Fire Marshal Pre-application Comments

Project: Crytyl 39 lot long plat
Site Address: N Pfenning Rd
Permit#: EX25-008
Occupancy Type: Residential Platt
Date: 07/29/25

SHEET NAME
PRELIMINARY PLAT

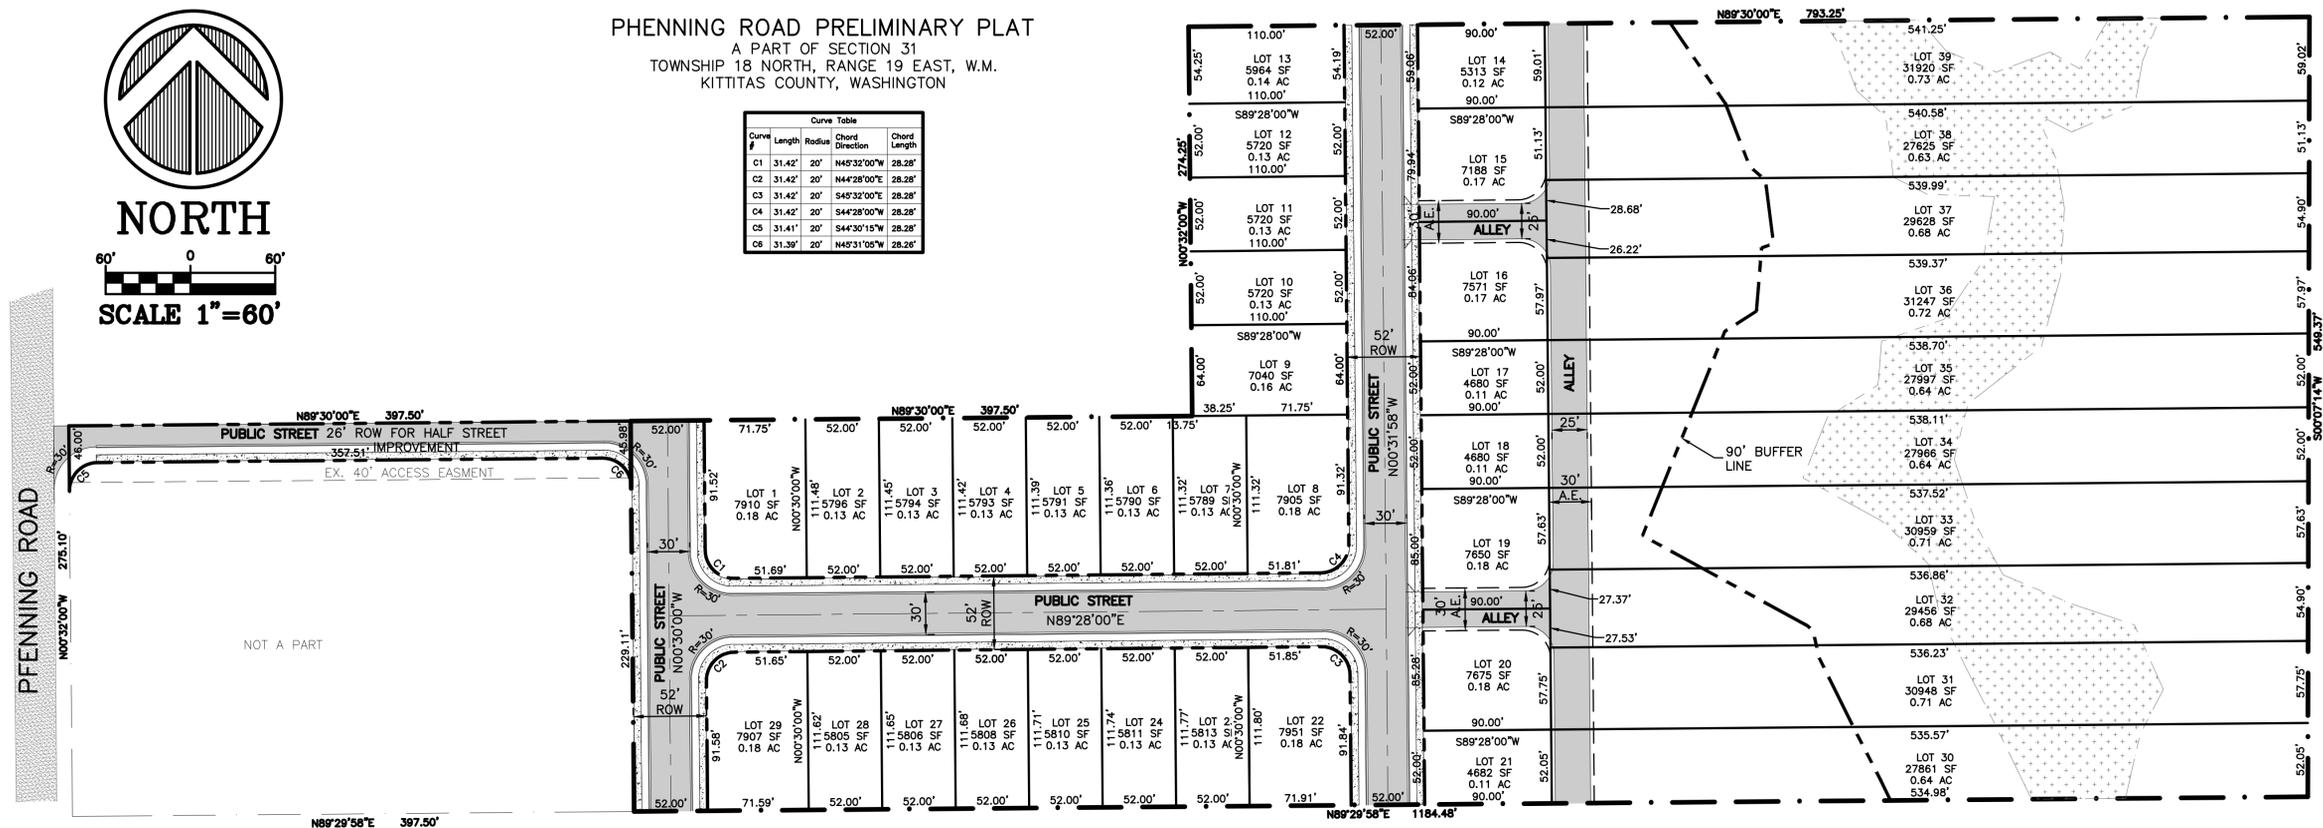
- 5) Current plat design only has one fire access road. Per Appendix D of IFC Section D107 One- or two-family developments. D107.1 ...Developments of one- or two-family dwellings where the number of dwellings exceeds 30 shall be provided with two separate and approved fire access roads. As AHJ for city of Ellensburg it would be acceptable to plat the 39 lots and limit building to 30 dwelling units until such time that it can be shown that future development will connect to secondary fire access road or any acceptable alternate means and method which would reduce the hazard.
